**From:** Contact Centre (CRM) <contact@ribblevalley.gov.uk>  
**Sent:** 03 March 2025 10:18  
**To:** Planning  
**Subject:** Planning Application Comments - 3/2025/0025 FS-Case-692265786

**Planning Application Reference No.:** 3/2025/0025

**Address of Development:** Middle Studlehurst Barn  
Osbaldeston Lane  
Osbaldeston  
BB2 7LZ

Drawing Title
Garage Plan, Elevation and 3D Views

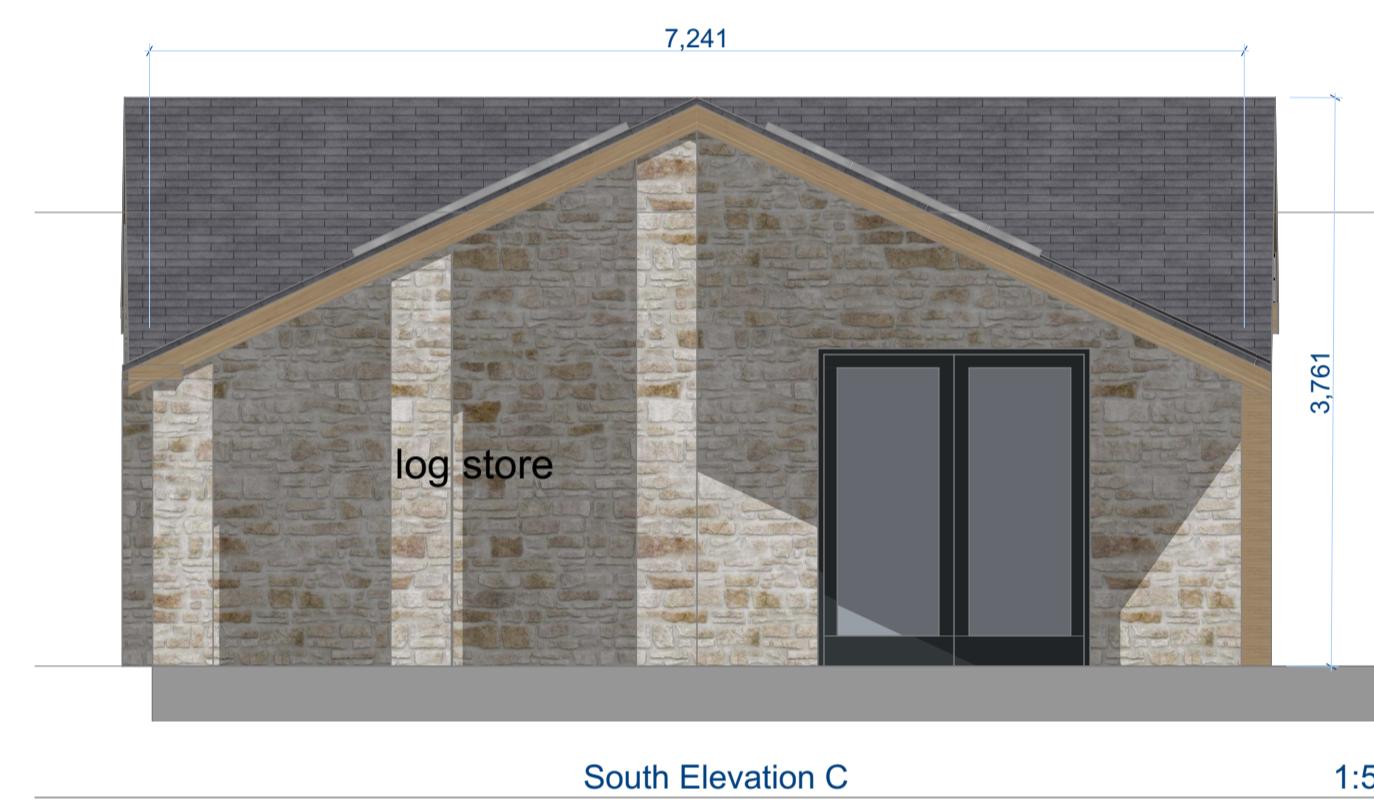
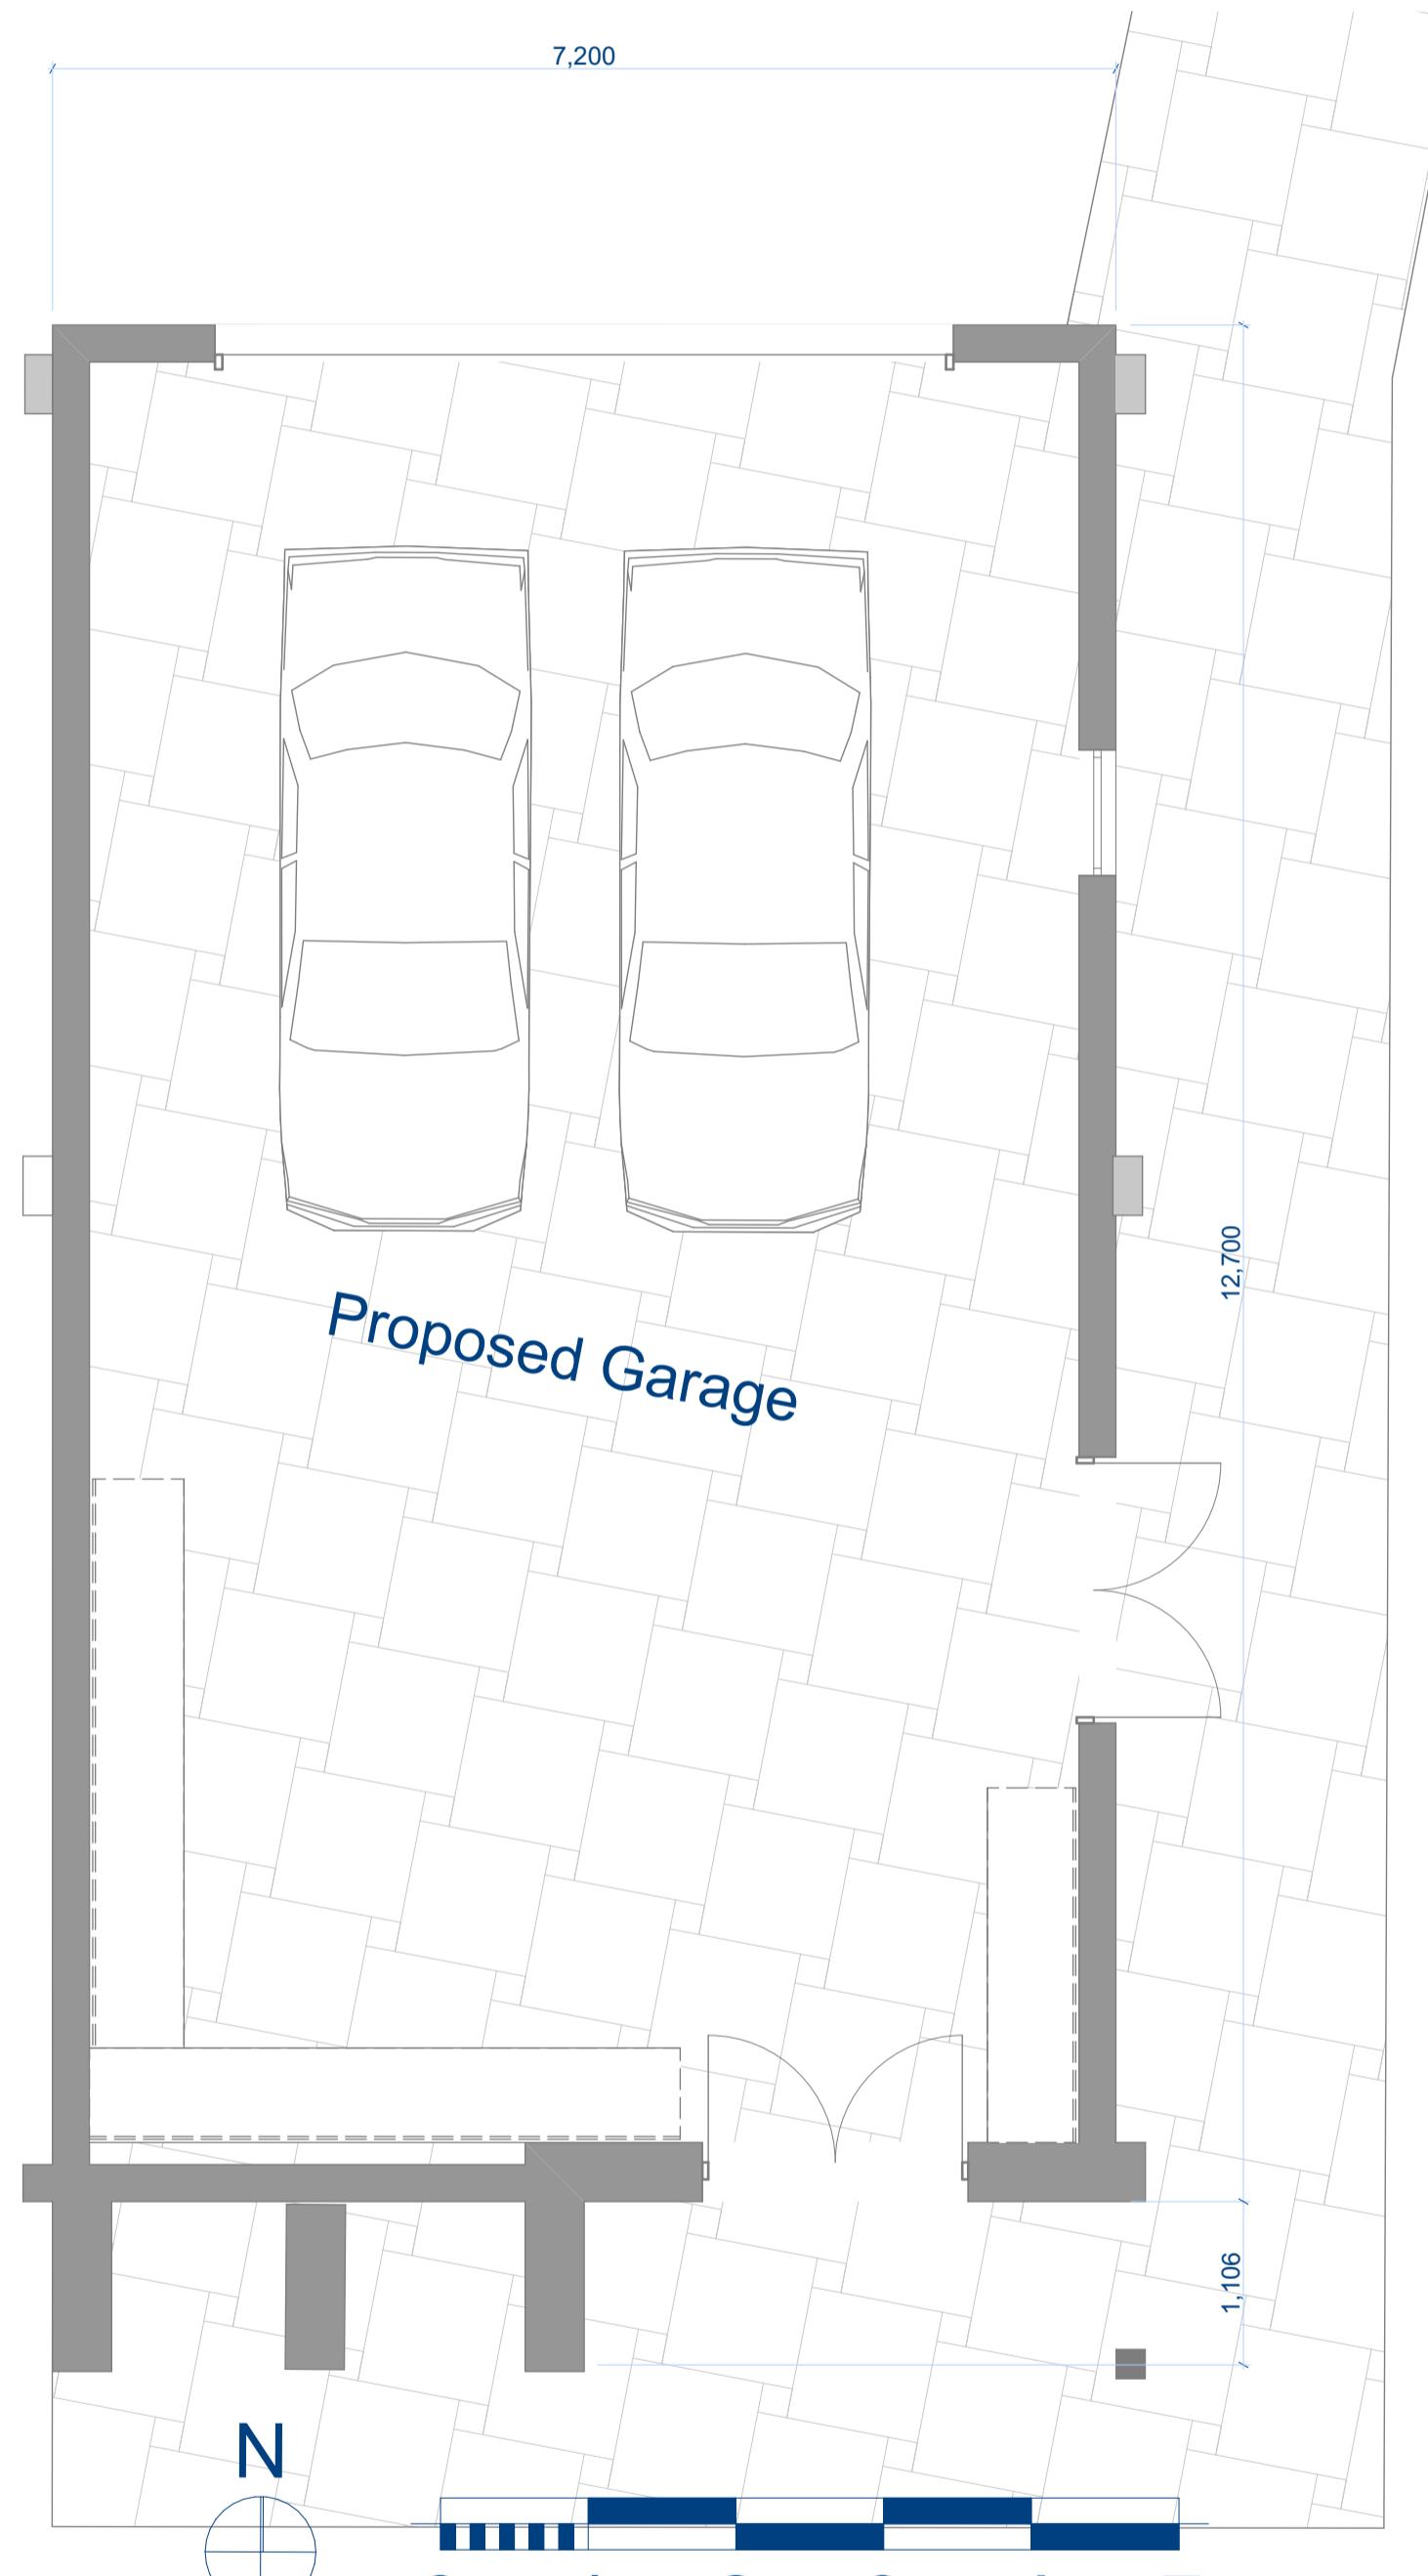
**Comments:** Following the submission of the above mentioned planning application, I am confirming that I have no objection to the amended garage plan dated 28th February 2028 as the ridge line is no higher than the current garage.

Drawing Title  
Garage Plan, Elevation and 3D Views

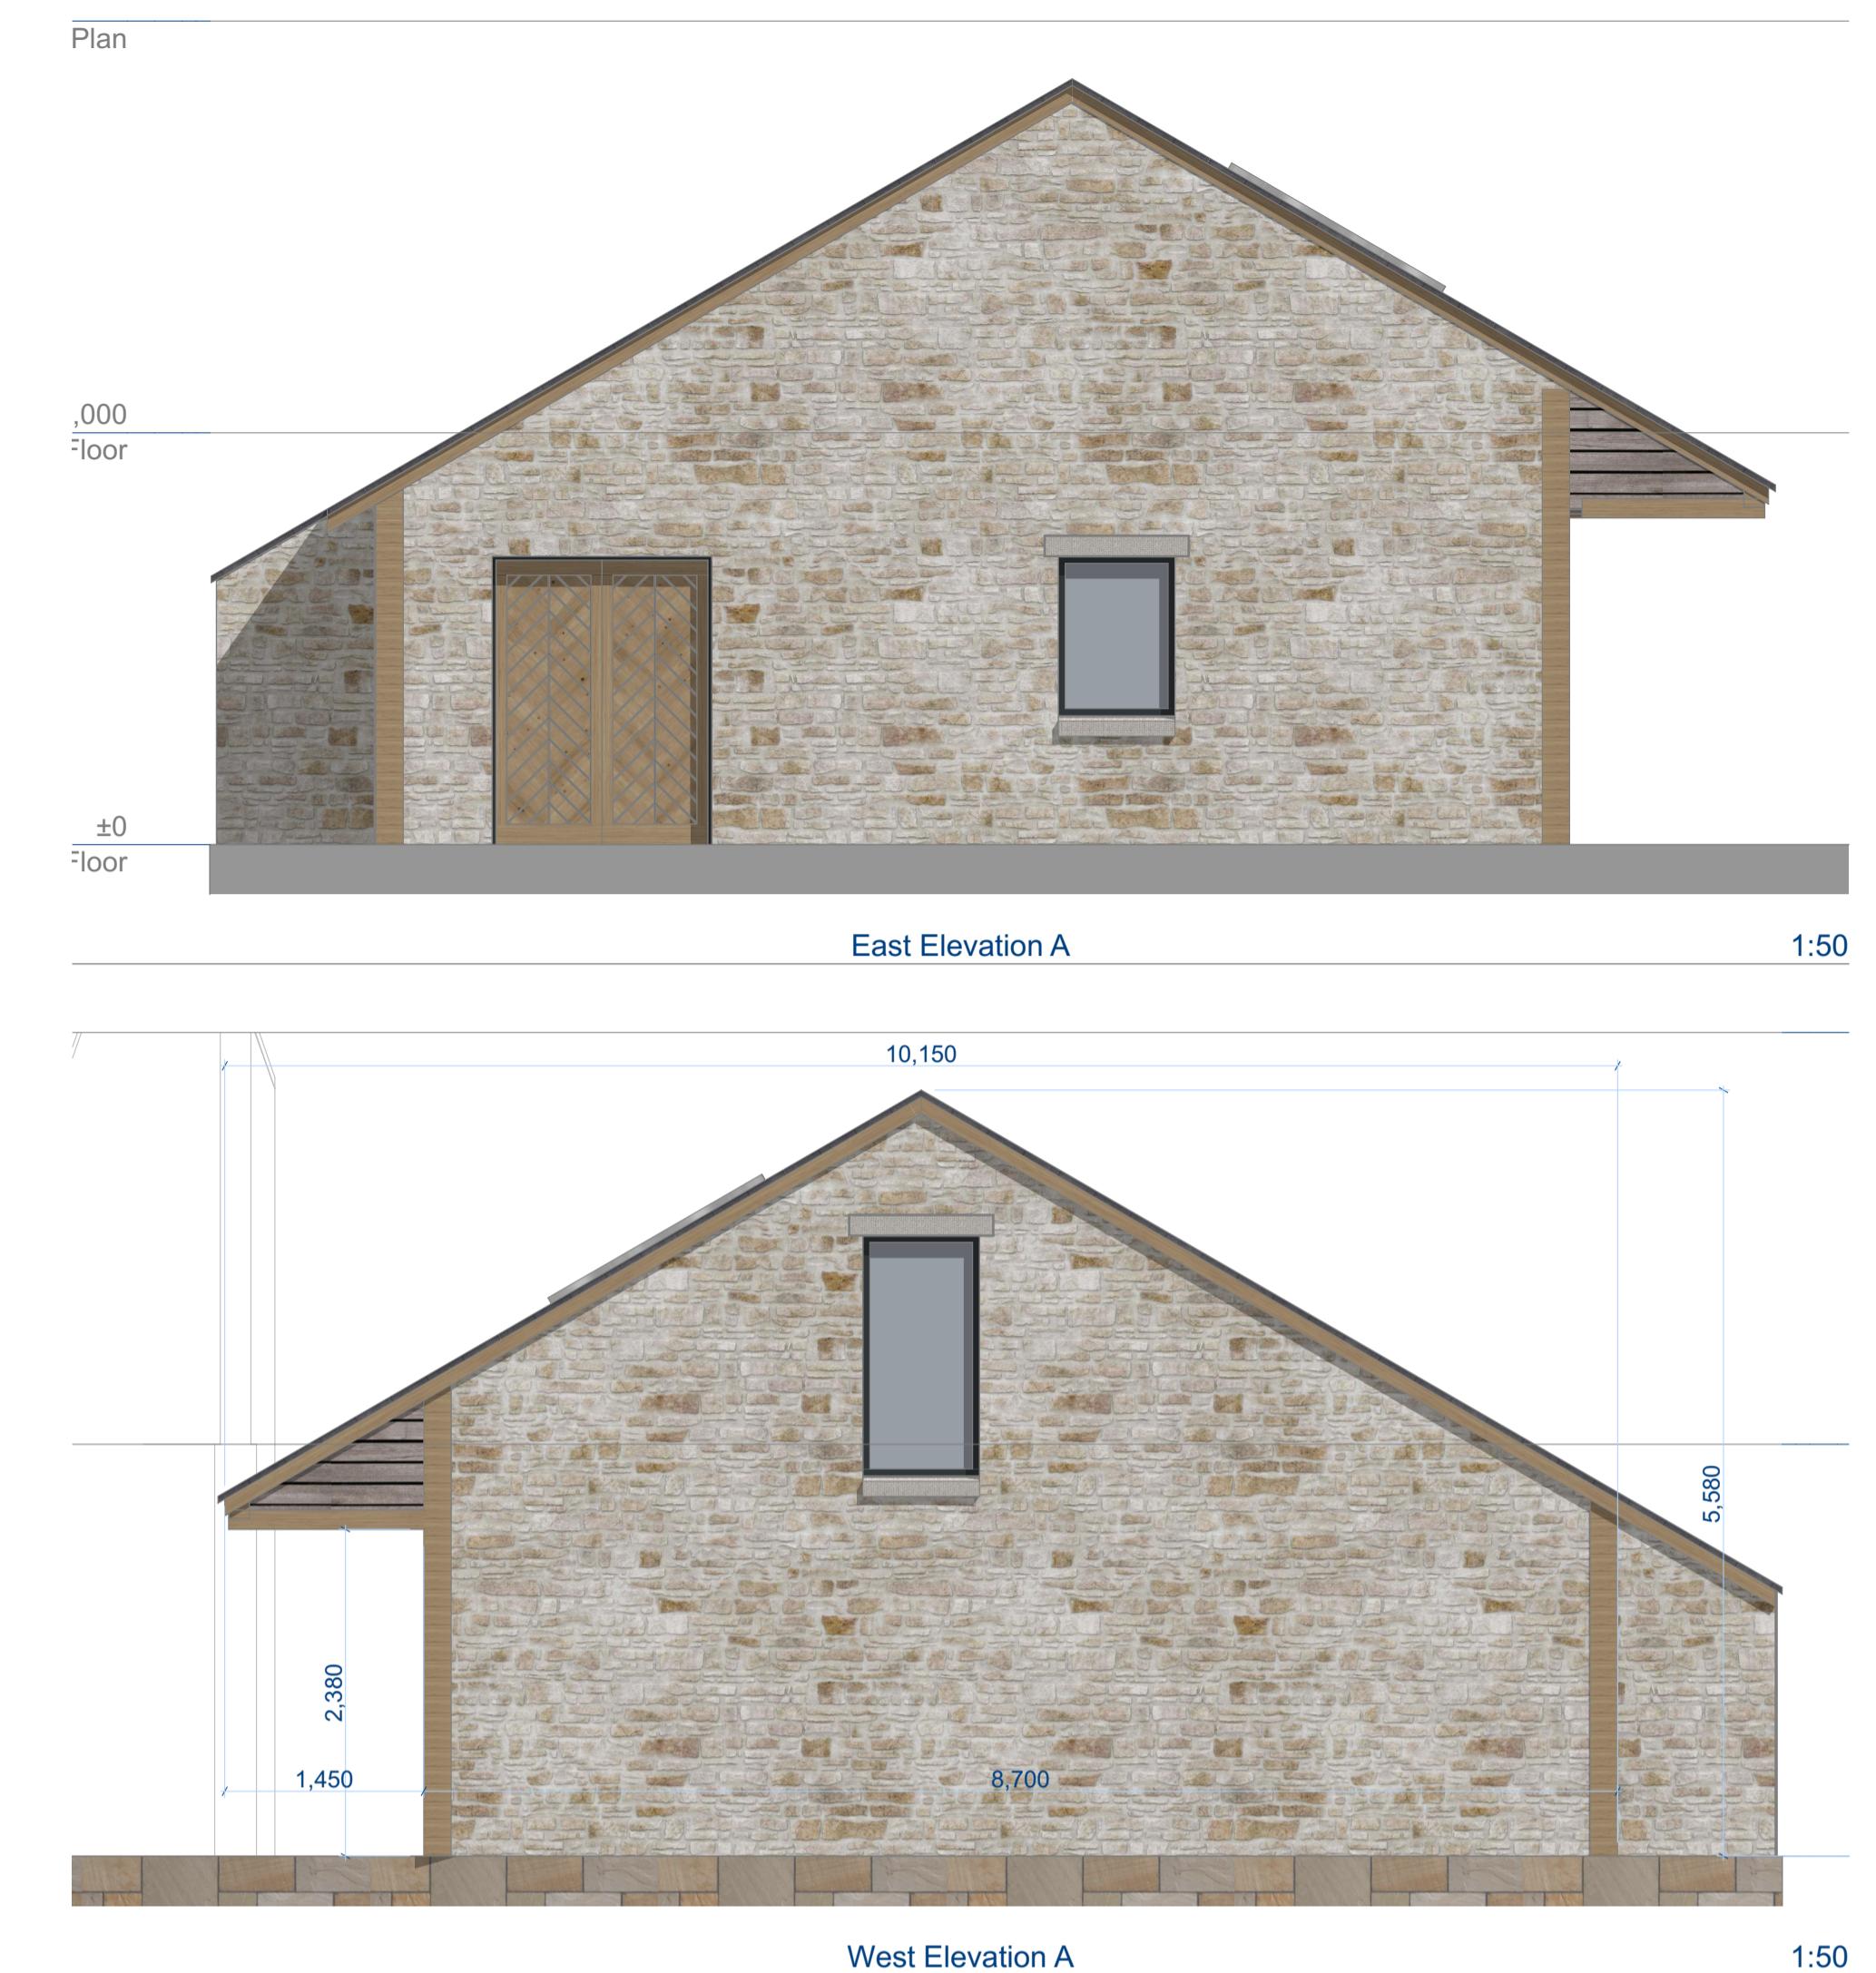
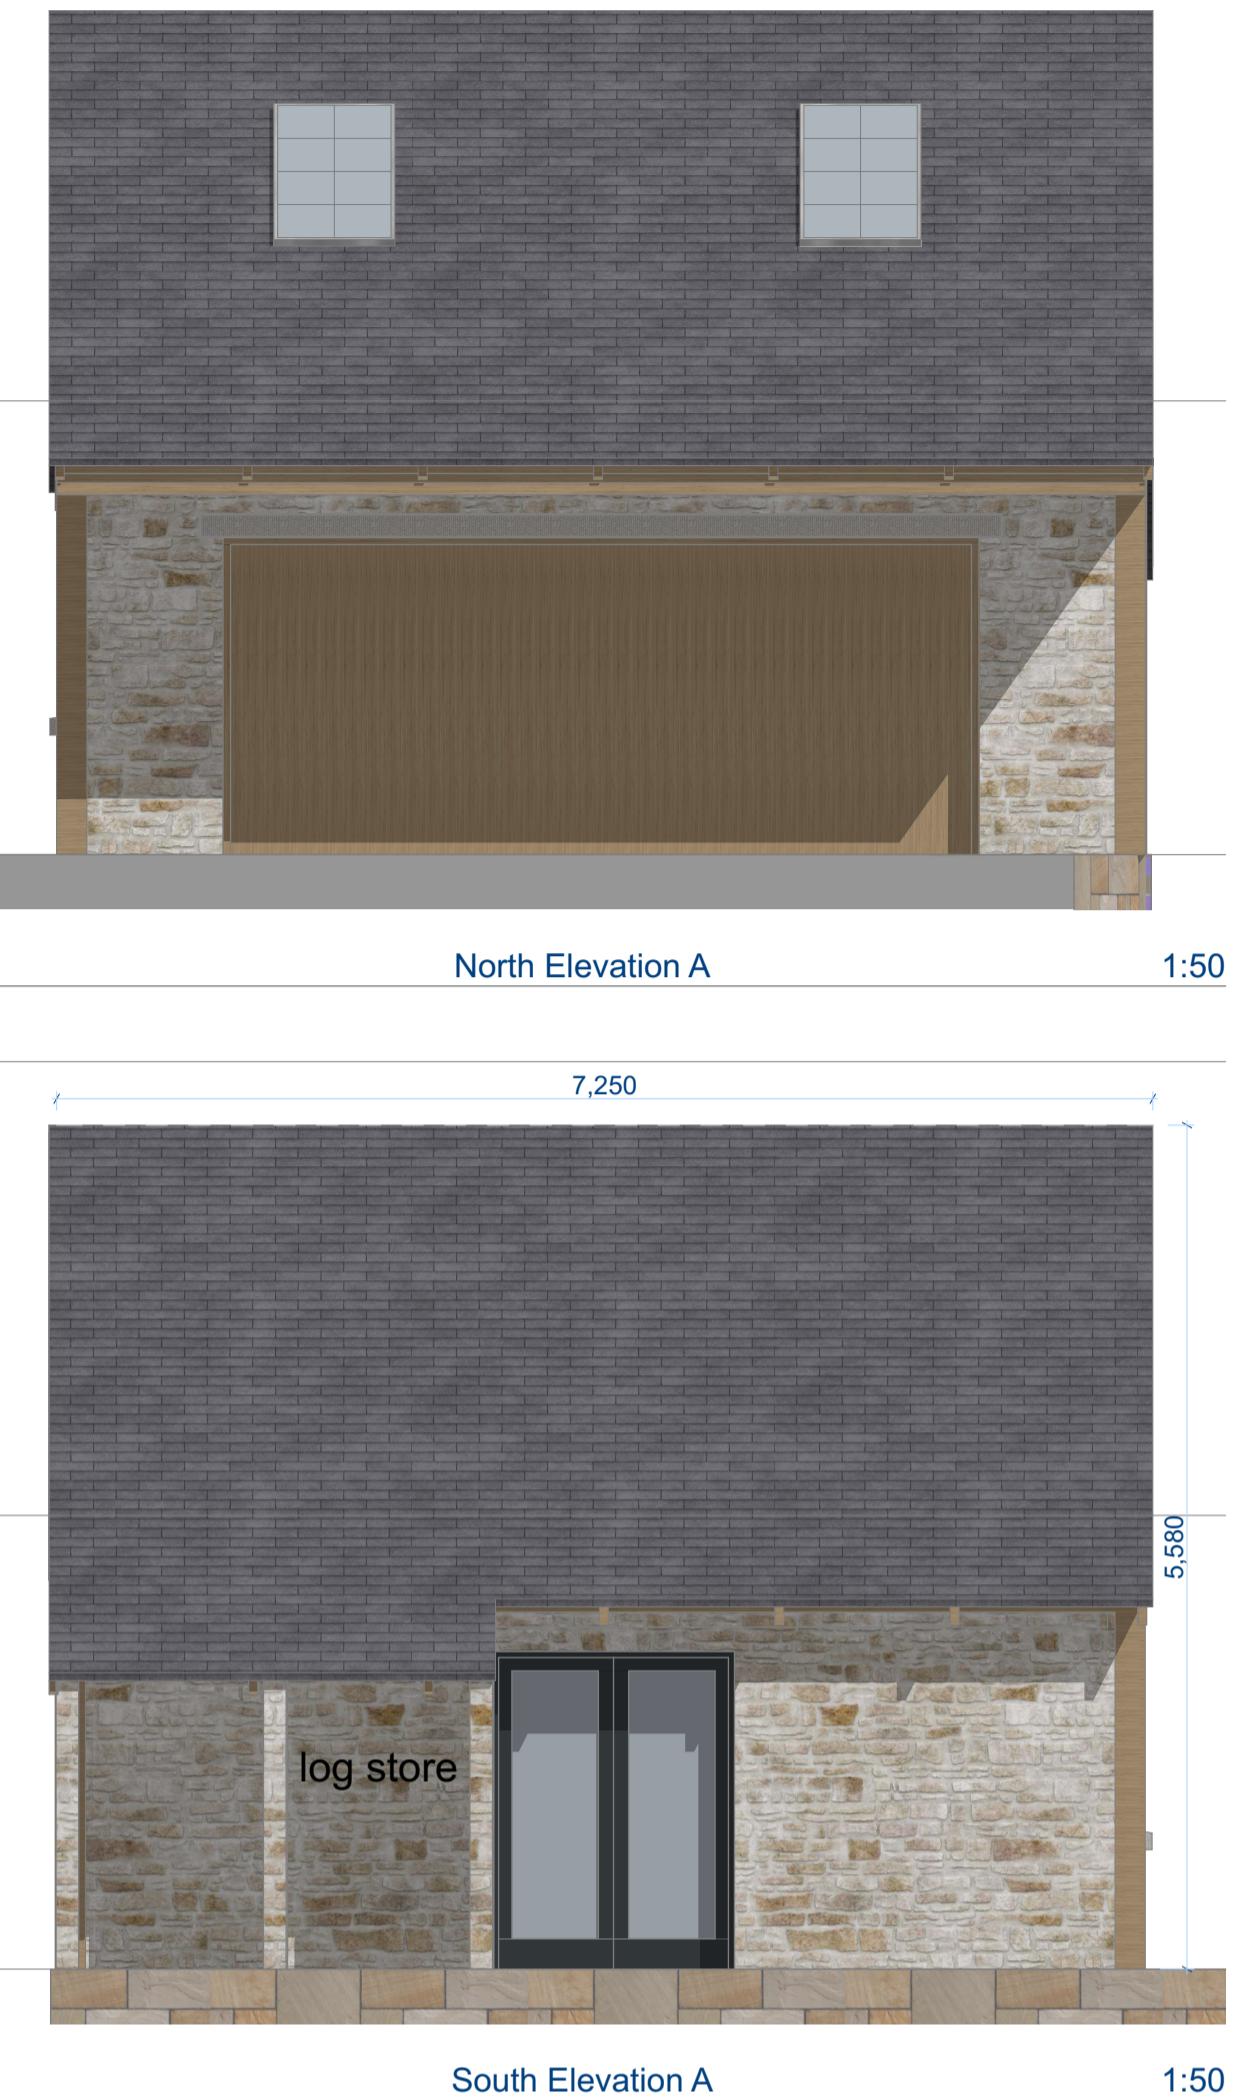
I was initially most concerned with the original plan as this totalled 5.58metres in height some 1.83metres higher than the existing garage.
